DRAFT ENVIRONMENTAL STATEMENT (VOLUME III) **Schedule of Changes to the dDCO**

HyNet Carbon Dioxide Pipeline DCO

Document Reference Number D.3.3

REVISION: B

**DRAWING TITLE**  
**WORKS PLAN REGULATION 5(2)(i) APPLICATION DOCUMENT REFERENCE D.2.4 SHEET 3**

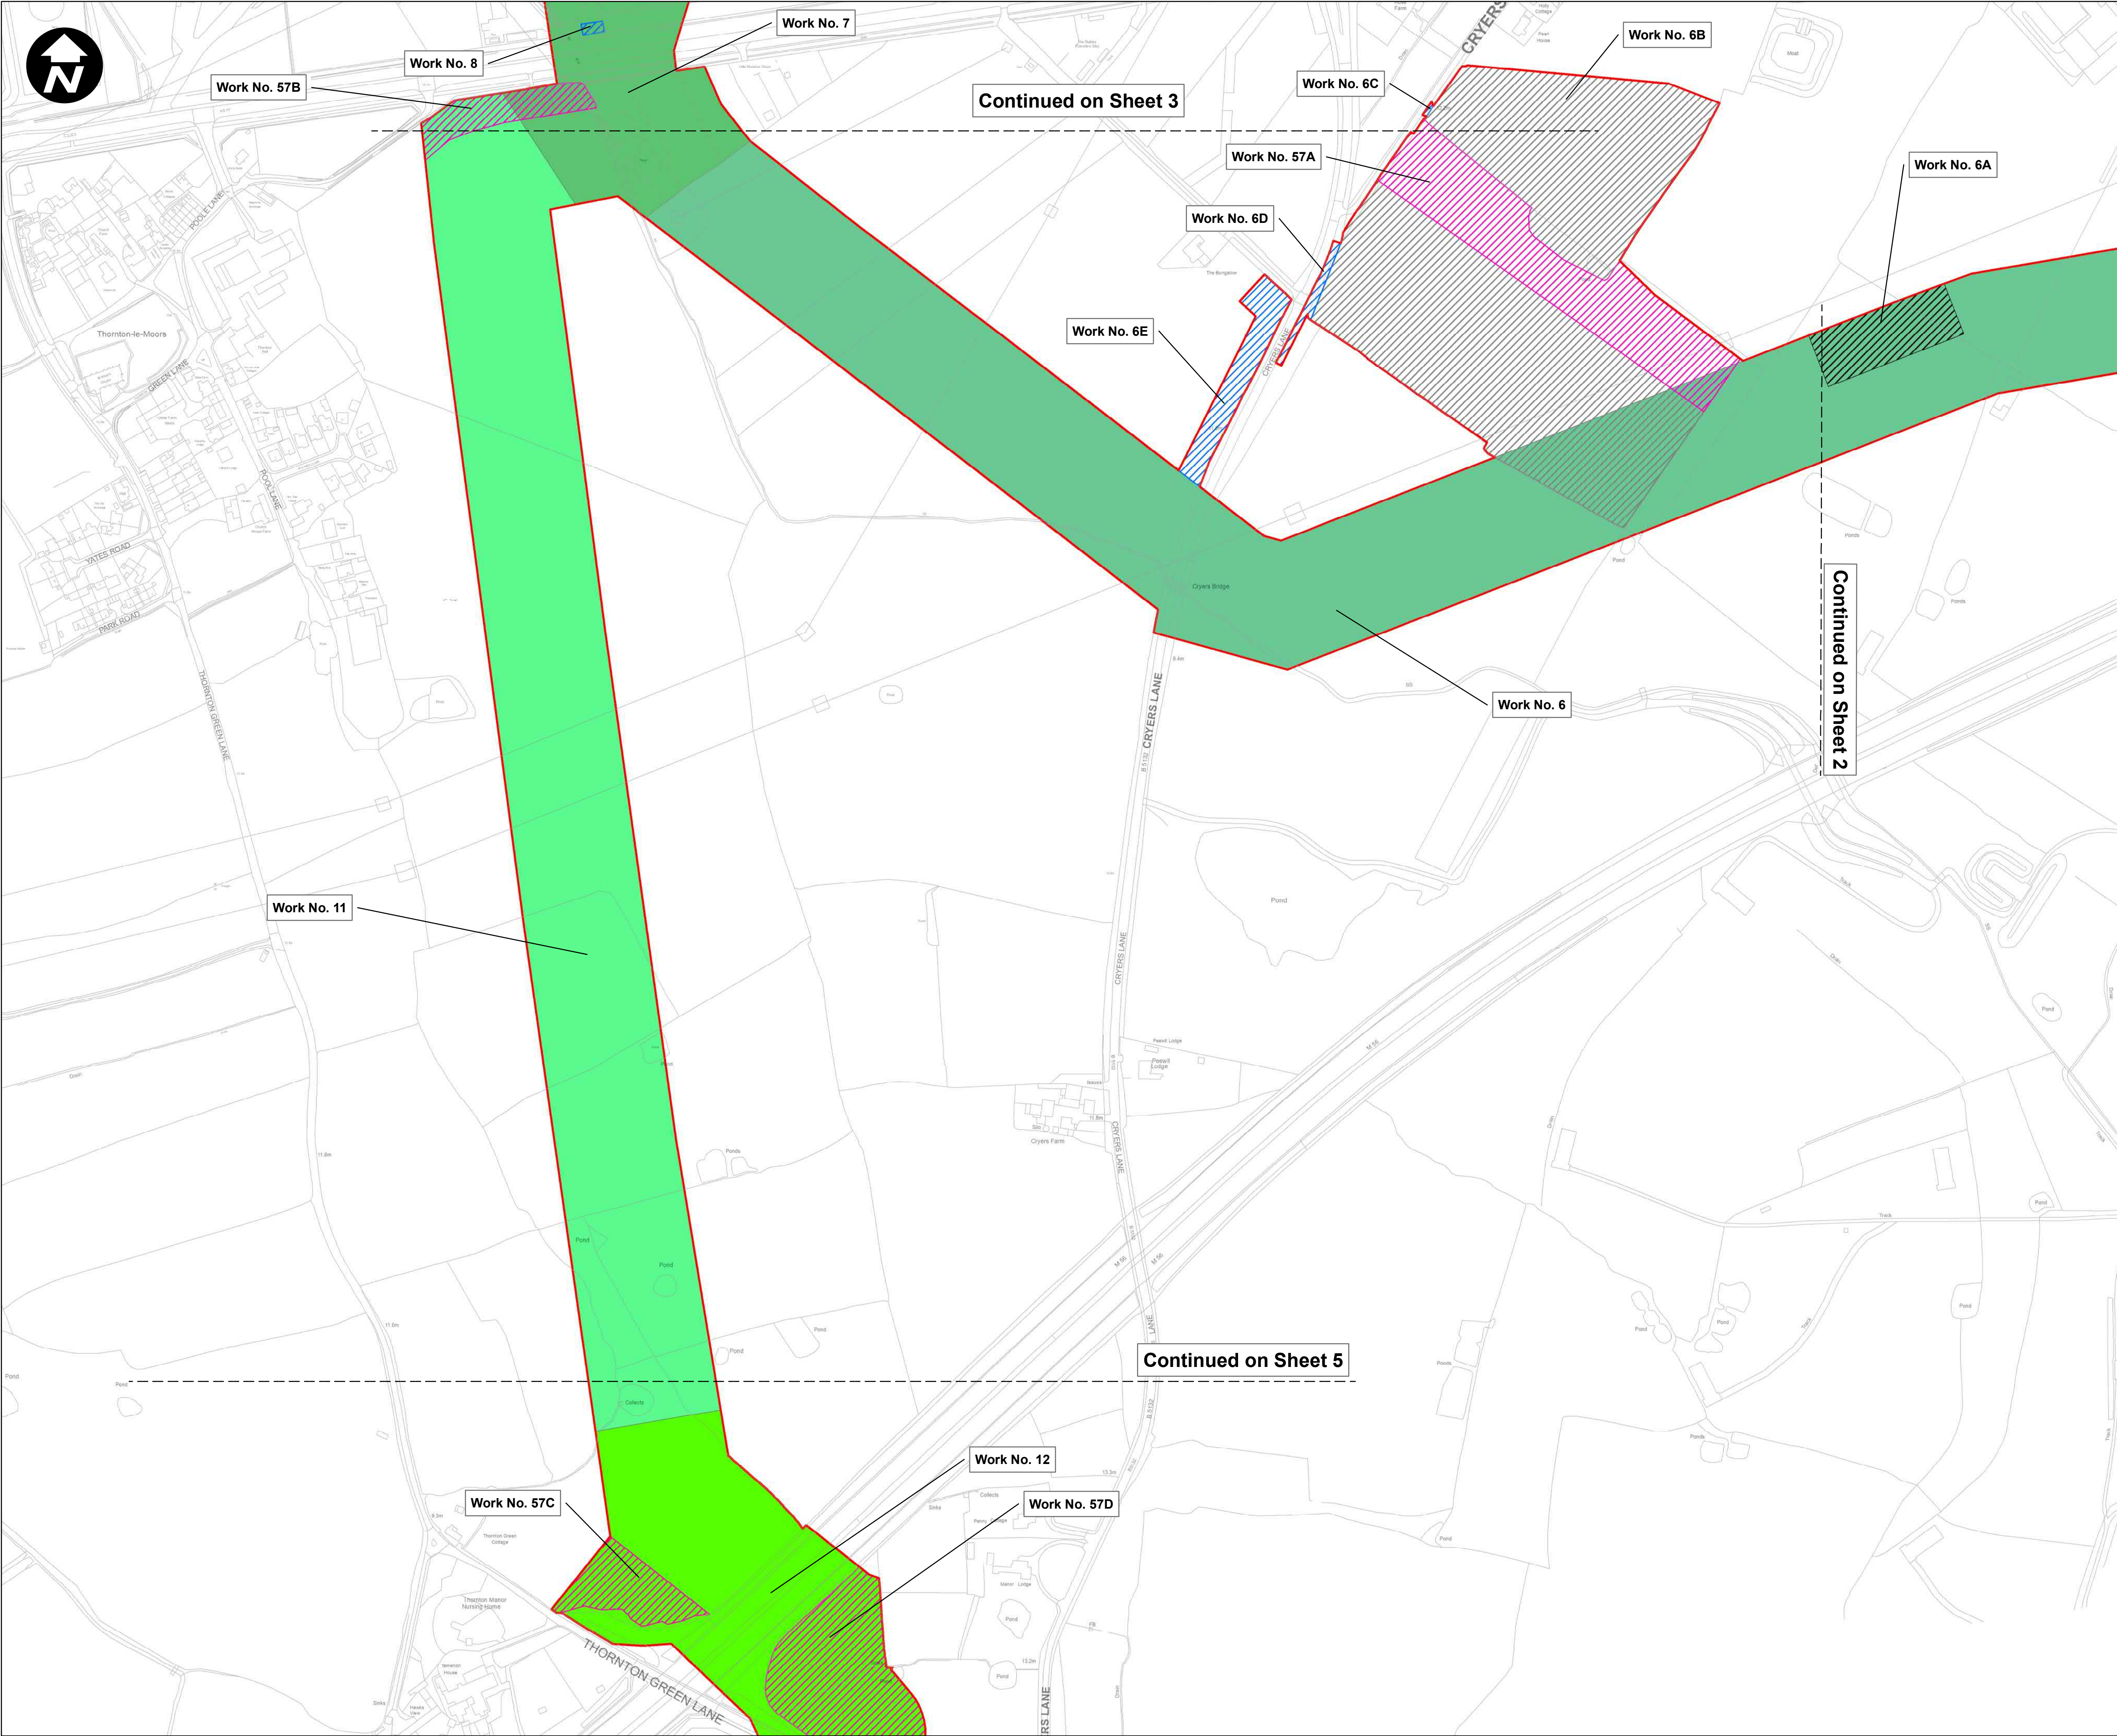
Reference	Amendment	Reason
Articles		
n/a		
Schedules		
Schedule 1 (authorised development)	Minor corrections from 'Work Plans' to 'Works Plans' throughout and insertion of missing 'and' in lists.	For consistency.
	The Works descriptions were amended as follows: <i>Work No. 3:</i> The creation and use of a permanent vehicular access to the authorised development, from the <u>Pool Lane/Oil Sites Road roundabout via the unnamed road (private road) and via the unnamed road (private road) from Ash Road unnamed road</u> within the location shown on Sheet 1, <u>Sheet 1a and Sheet 3</u> of the Works Plans, including—	To reflect the changes sought as part of the change request.

**EN070007-D.2.4-WP-Sheet 7**

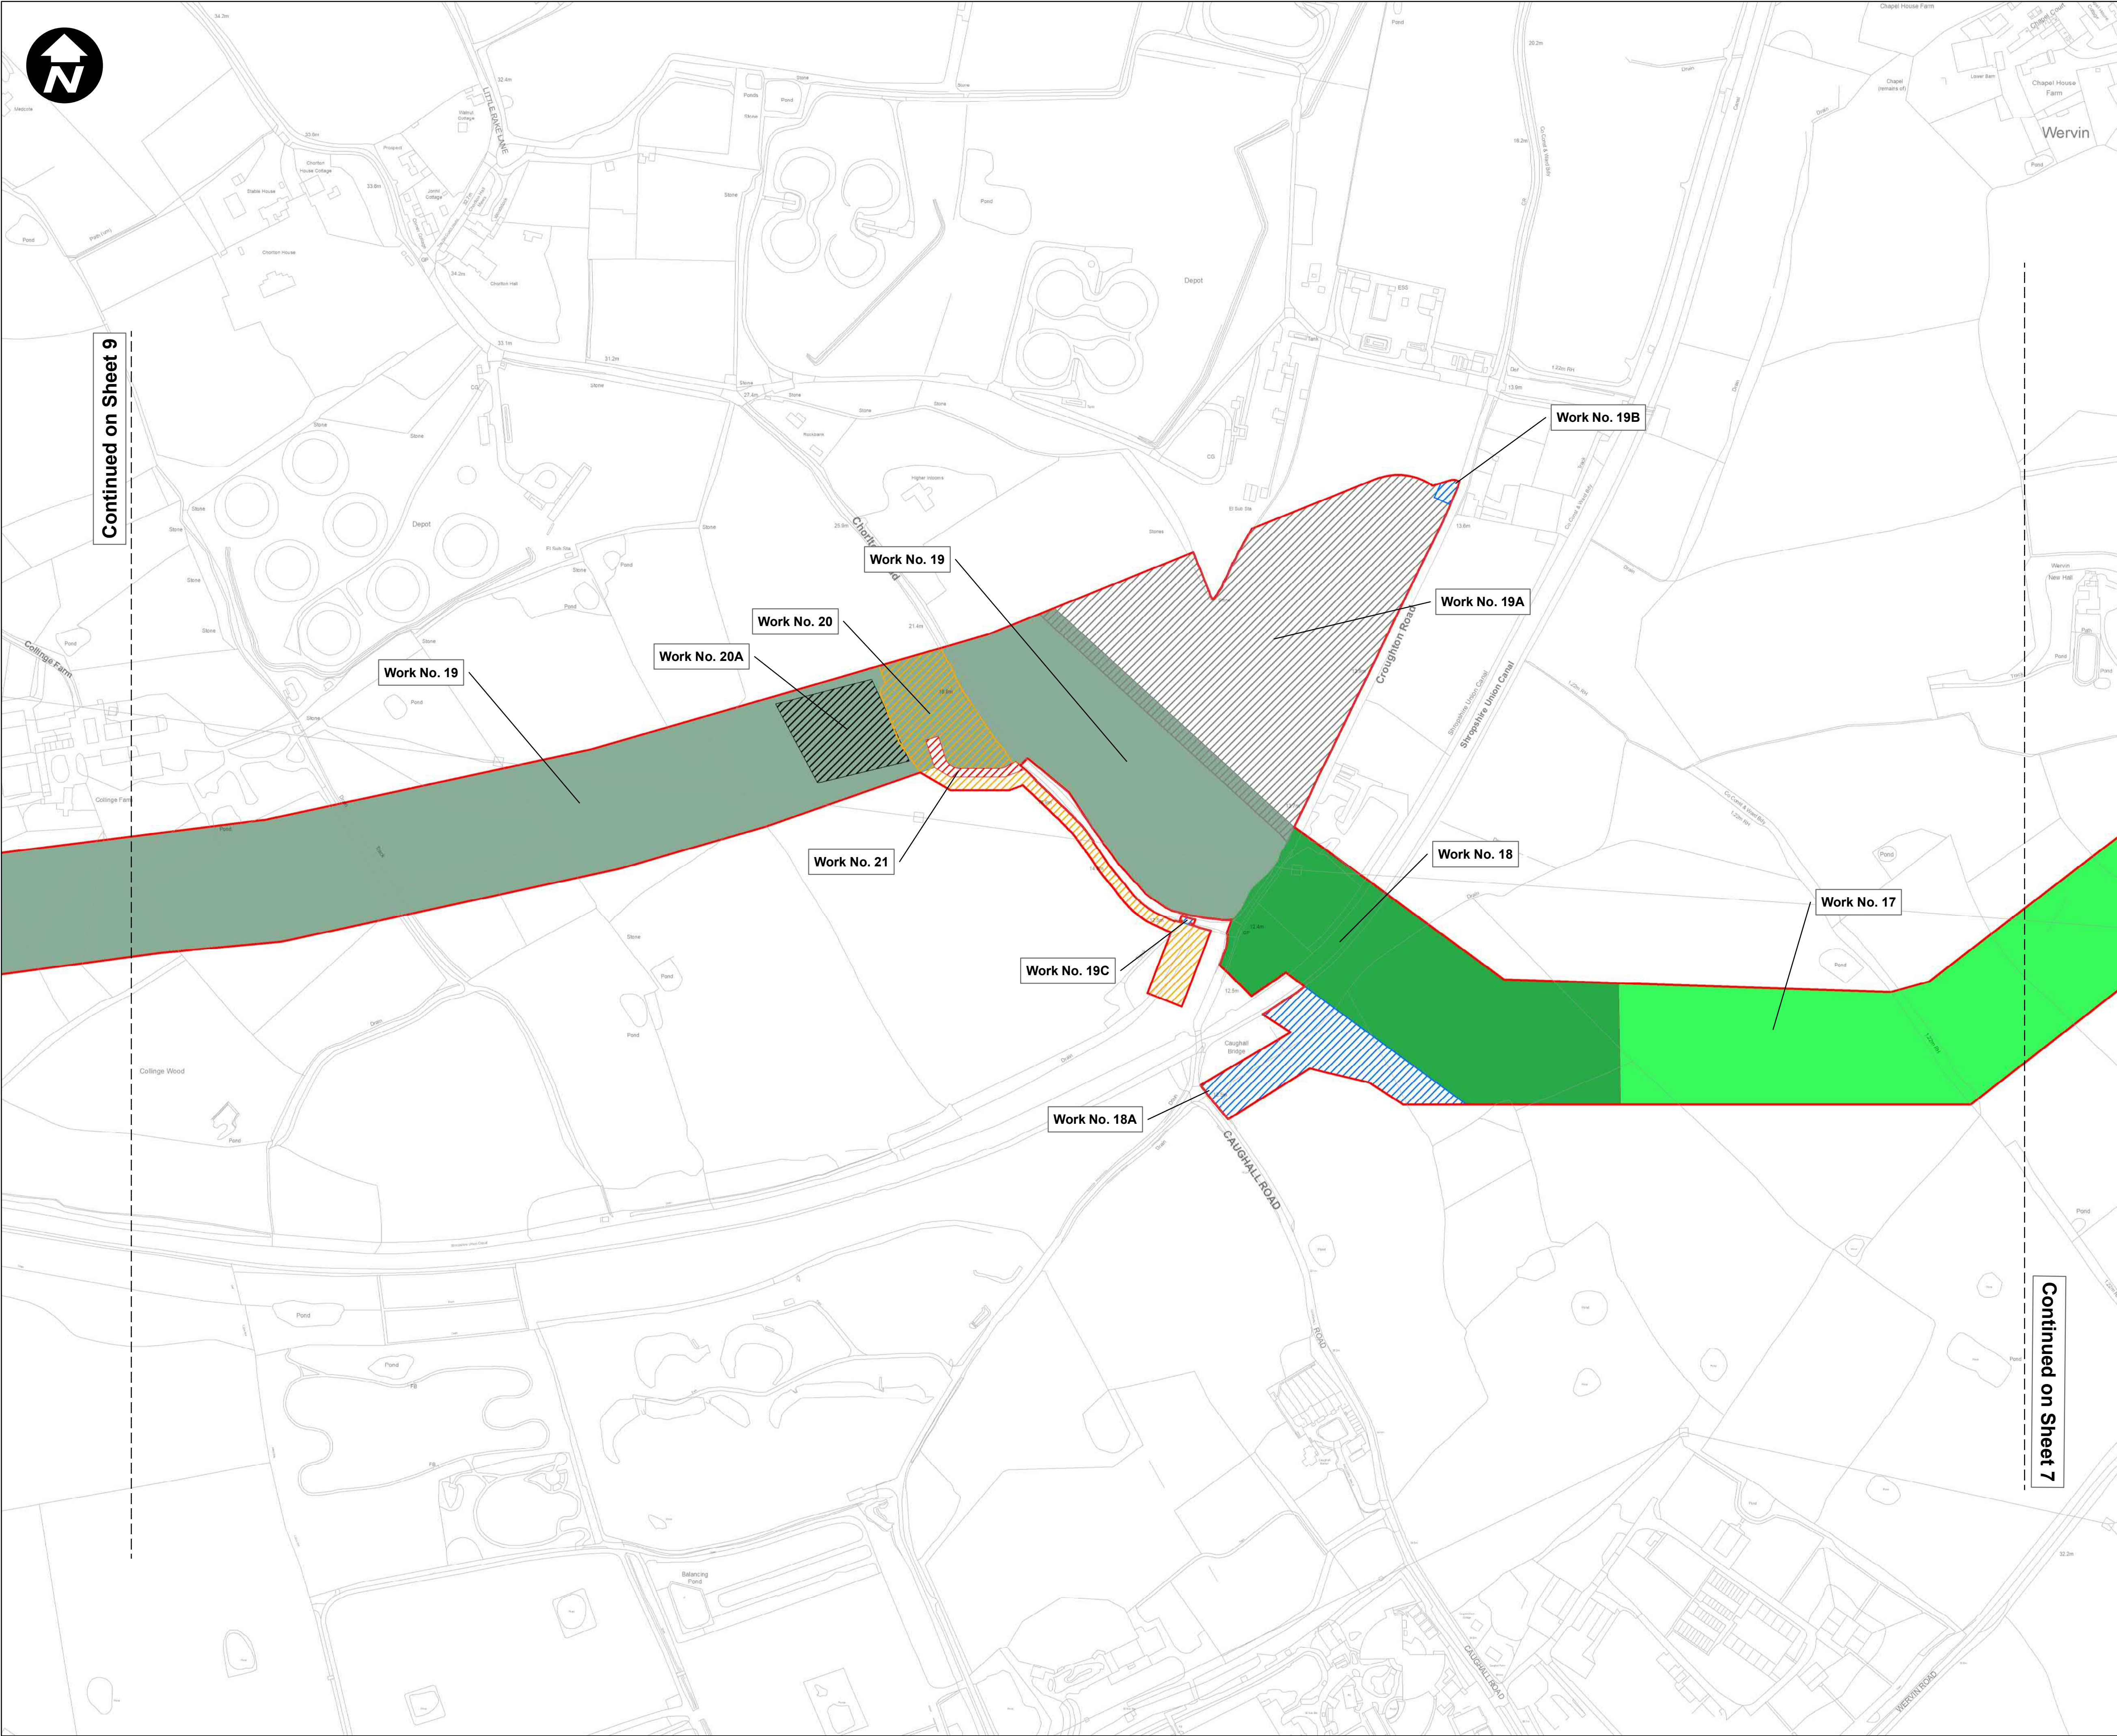
1. <i>Work No. 16A:</i> Creation and use of a permanent access from Picton Lane, within the location shown on Sheet 7 of the Work Plans, including— 2. creation of a new bellmouth junction with the public highway; and improvement of road surfacing and provision of new hard surfacing <u>(excluding on the Bridleway)</u> .	To reflect the changes sought as part of the change request
	New Work No. 16B inserted;	To reflect the changes sought as part of the change request

<p><u>Work No. 16B: Creation and use of a temporary construction access from Picton Lane, within the location shown on Sheet 7 of the Works Plans, including—</u></p> <p>a. <u>creation of a new bellmouth junction with the public highway; and</u></p> <p>b. <u>improvement of road surfacing and provision of new hard surfacing.</u></p>	
	<p>Work No. 32A: Creation and use of a temporary construction access from the B5129private track, within the location shown on Sheets 14 and 15 of the Works Plans, including—</p> <p>improvement of an existing junction with the public highway; and</p> <p>improvement of road surfacing and provision of new hard surfacing</p>	To reflect the changes sought as part of the change request
	<p>New Work No.45B inserted;</p> <p><u>Work No. 45B: The creation and use of a permanent vehicular access to the authorised development, from B5125 within the location shown on Sheet 20 of the Works Plans, including—</u></p> <p>a. <u>improvement of road surfacing and provision of new hard surfacing;</u></p> <p>b. <u>creation of a new bellmouth junction and visibility splays; and</u></p> <p>c. <u>installation of utilities.</u></p>	To reflect the changes sought as part of the change request
